Demolition of existing garage & outbuildings. Alterations to external materials (including change from thatch to clay tiled roof and brick/stone to fibre cement weatherboarding and coloured render). Alterations to existing fenestration, including to 2 no. ground floor rear bay windows, and addition of first floor front dormer, enlarged balcony at first floor level at the rear. Replacement garages.

The Breakers 29 Tamarisk Way East Preston

Thank you for your internet representation made on 11th February 2020 which has been recorded as **'an objection'** with the comments as follows:

1:100 West Elevation

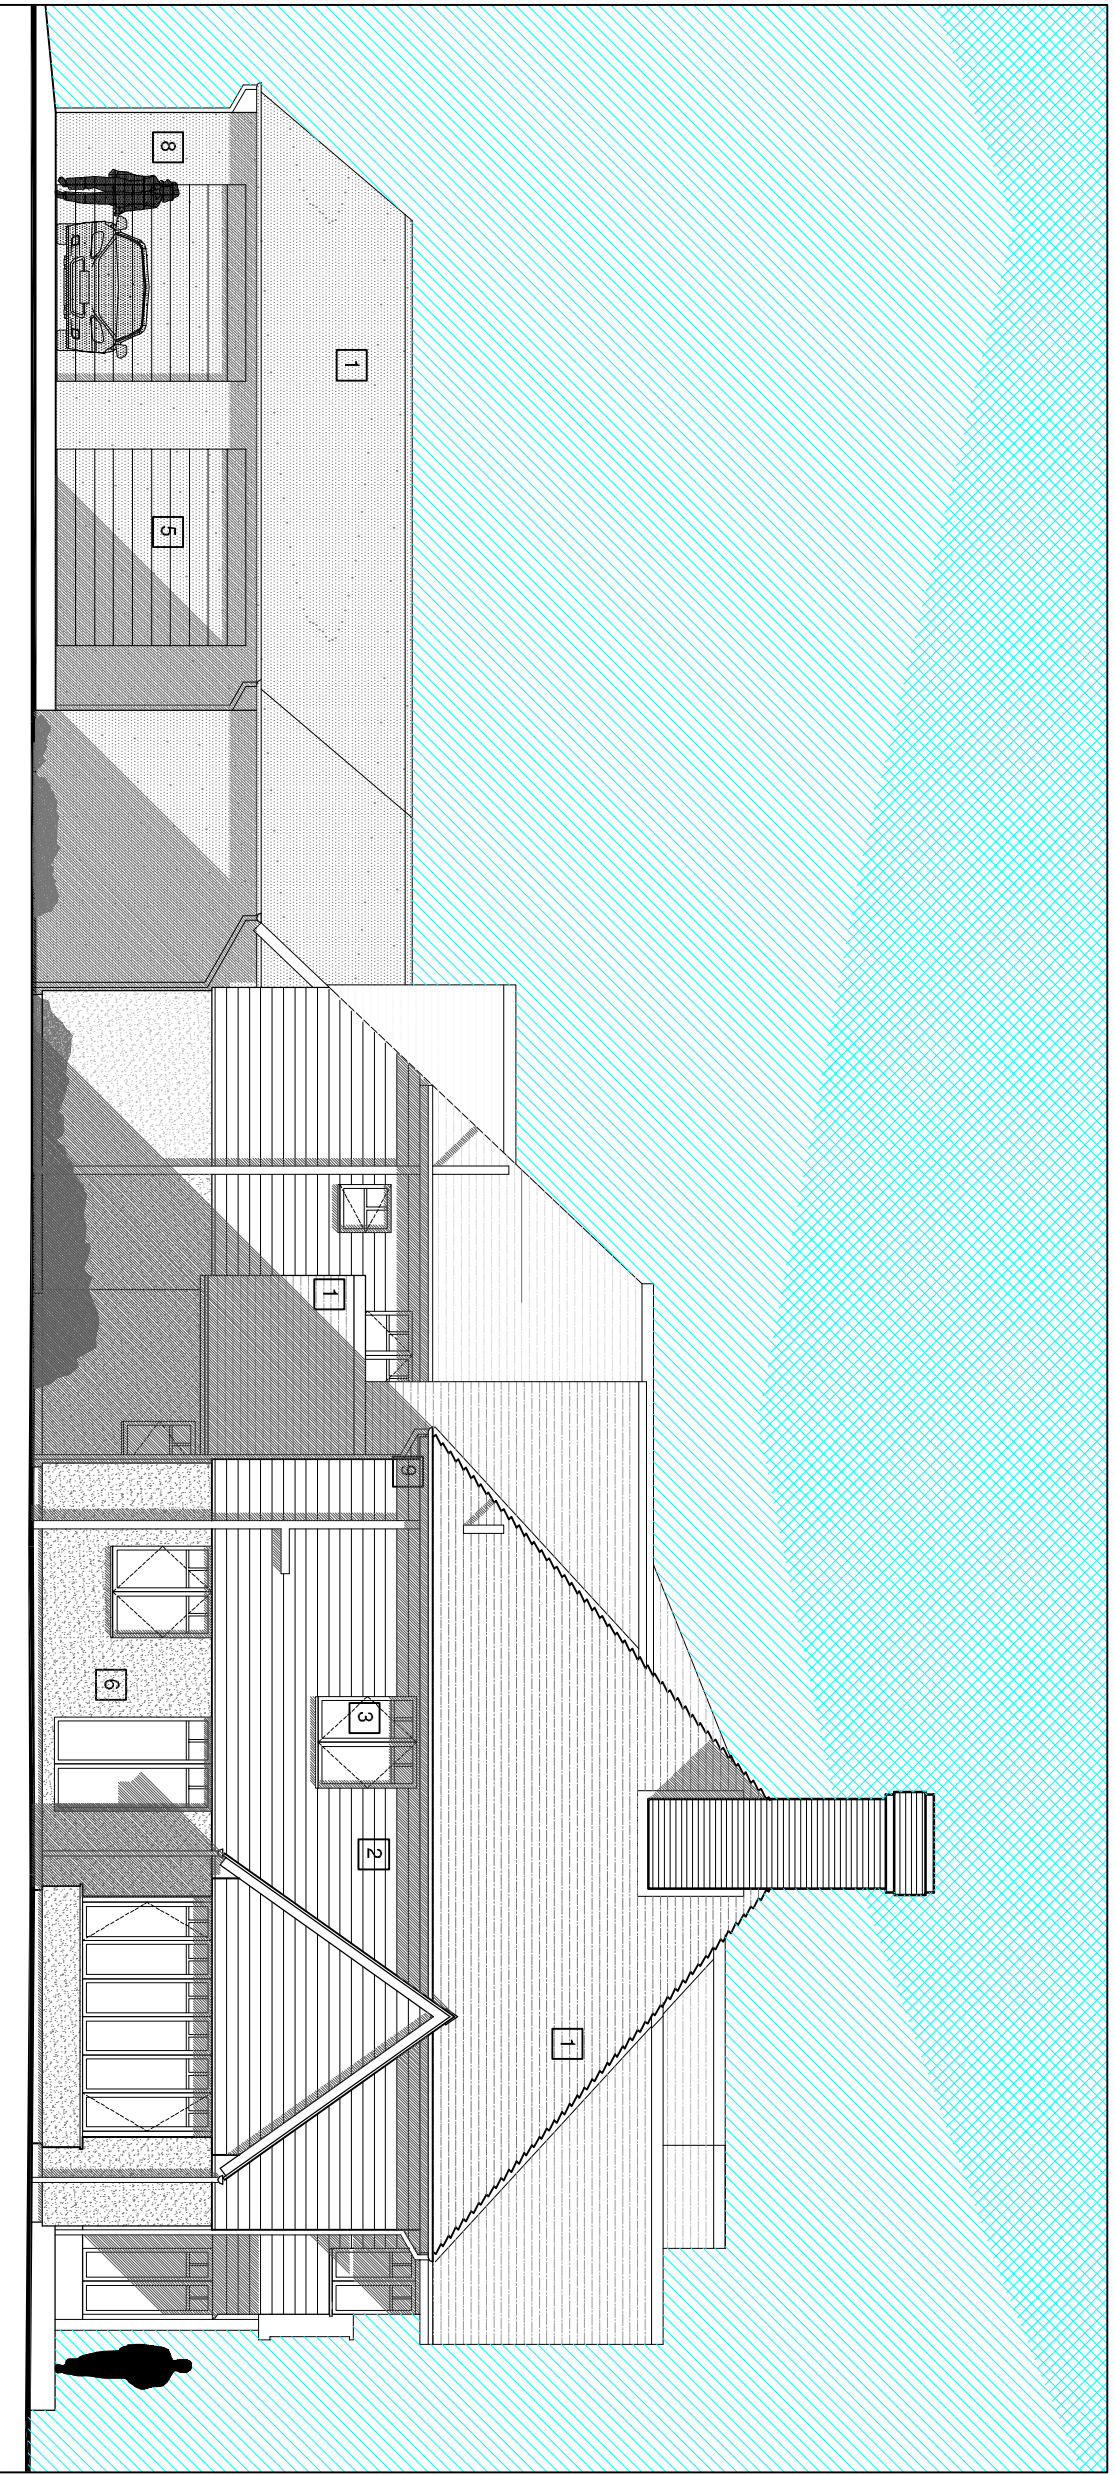
Thatching has been used for centuries and gives excellent thermal insulation, keeping a property warm in winter and cool in summer. It also provides excellent sound insulation and is very strong in high winds, whilst tiles are falling all around. As for fire risk, a properly constructed thatched roof on a well maintained property with modern electrical installations and sound brickwork around any used chimneys is no more likely to catch fire than a tiled or slate roof. Modern wood burning stoves installed into chimneys in poor condition is the main risk alongside electrical fault. This particular thatch has stood for nearly 100 years with no problem.

The Breakers, 29 Tamarisk Way, East Preston Boundary Wall and Gates as Proposed

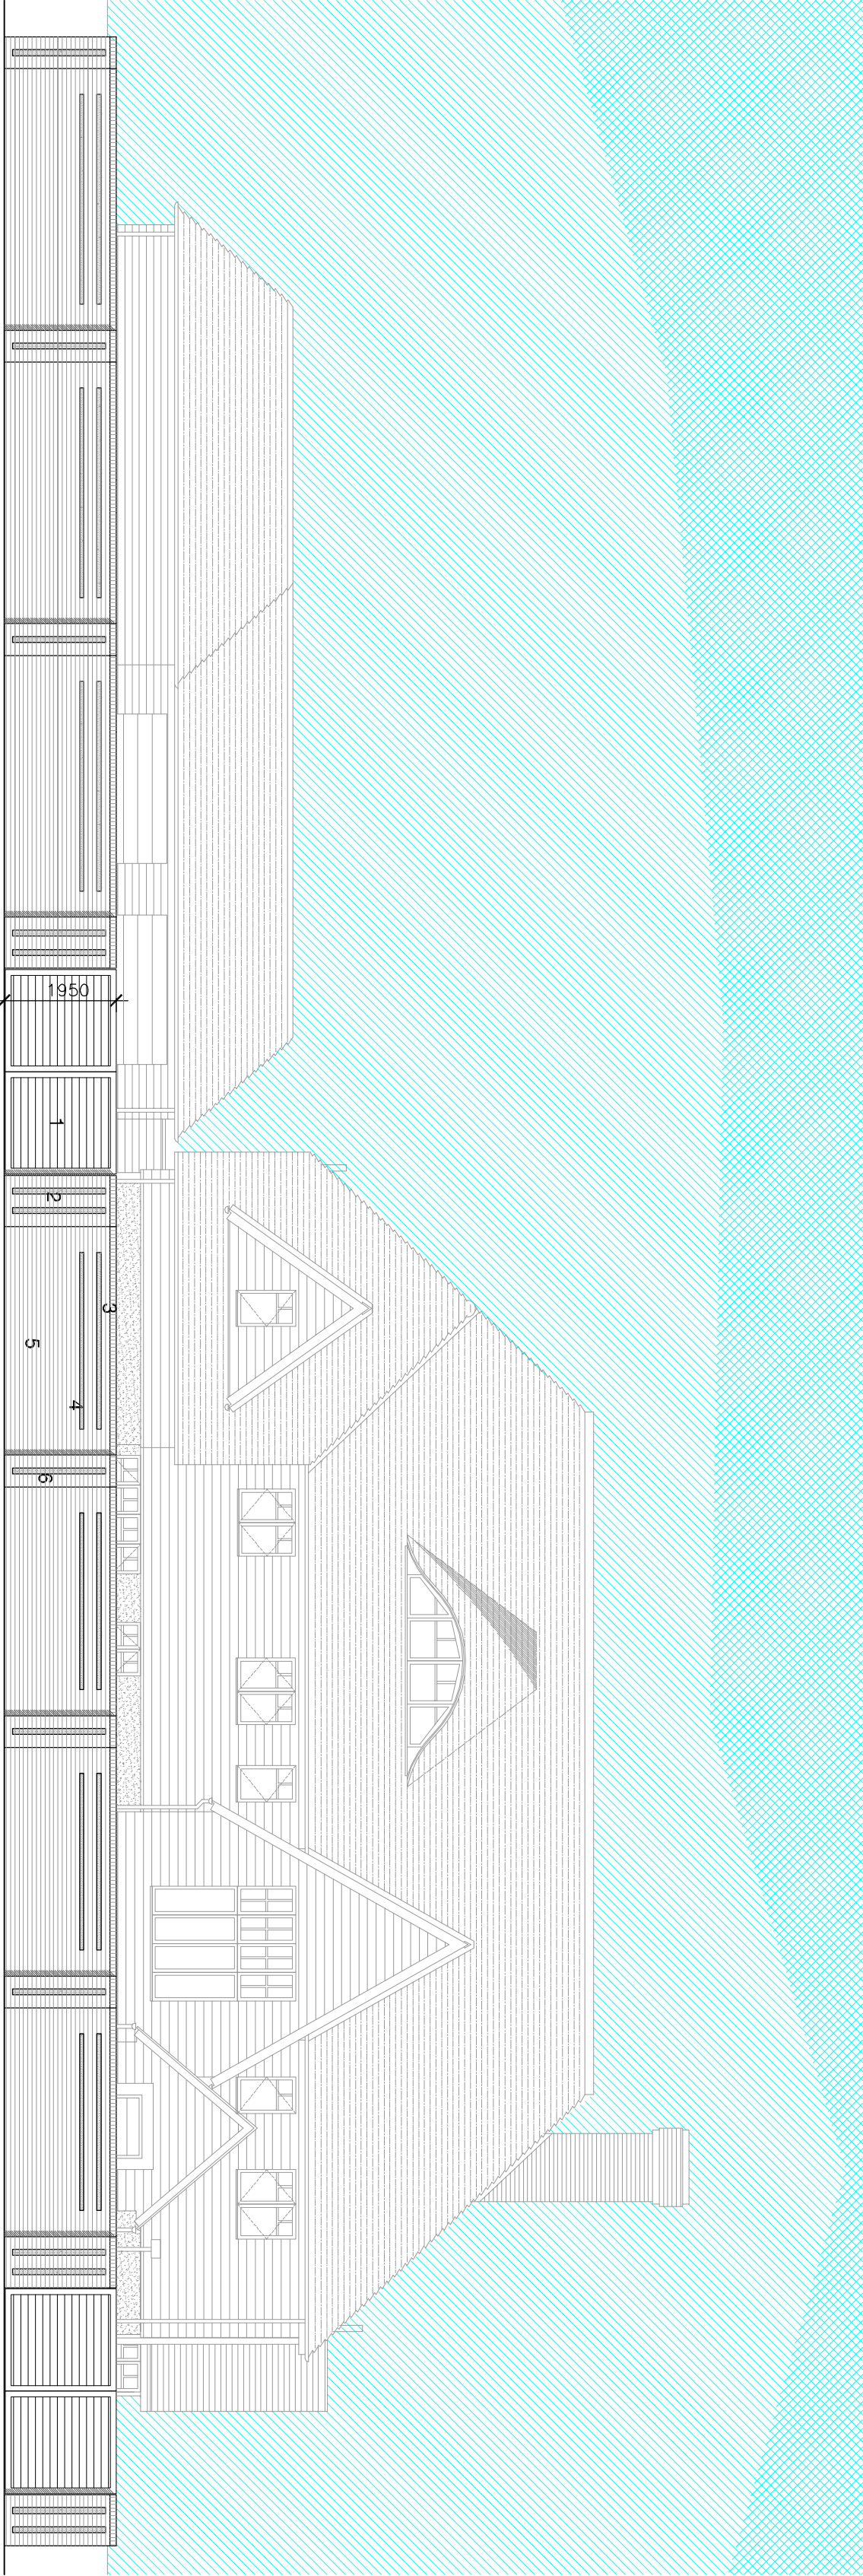
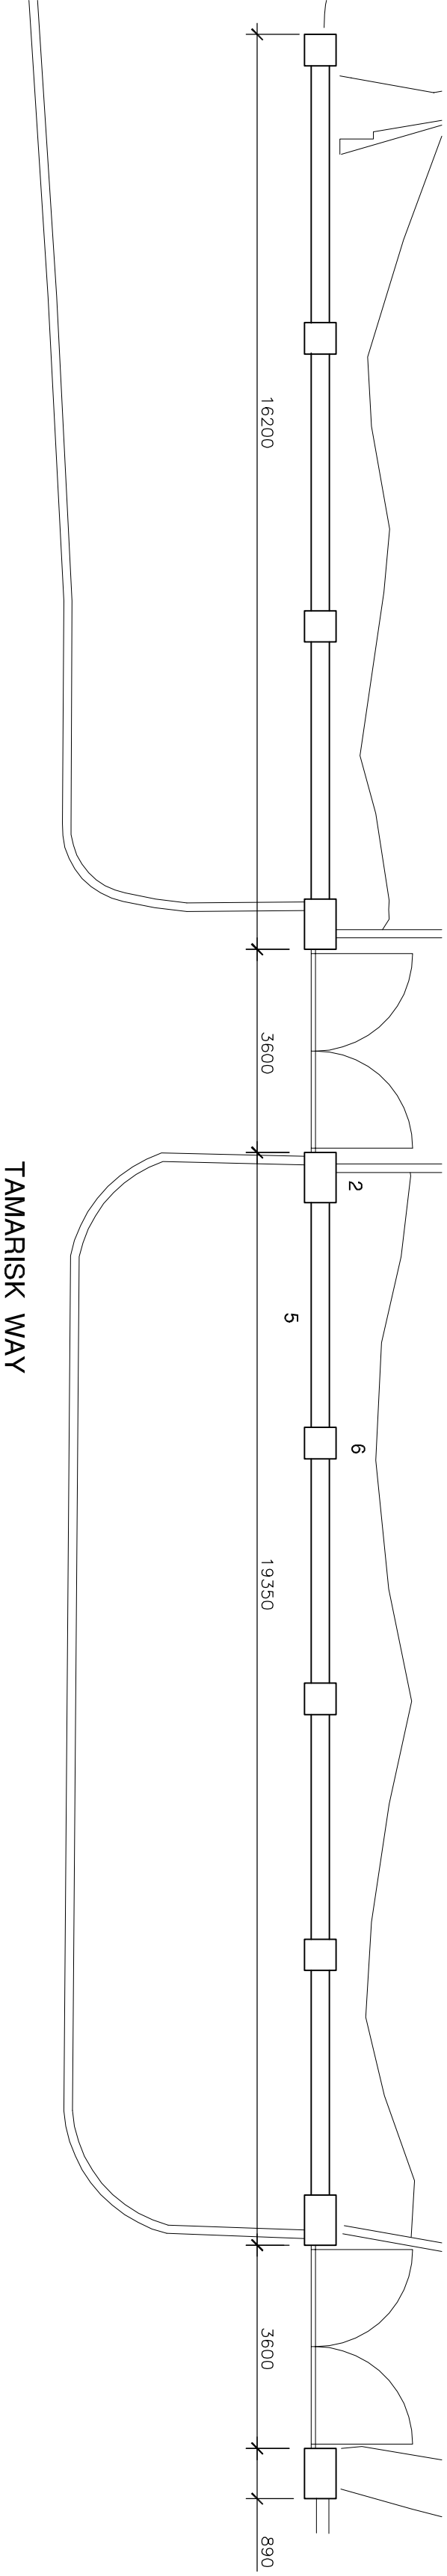
The proposed boundary walls are over bearing and are also not in keeping with the East Preston Neighbourhood Plan.
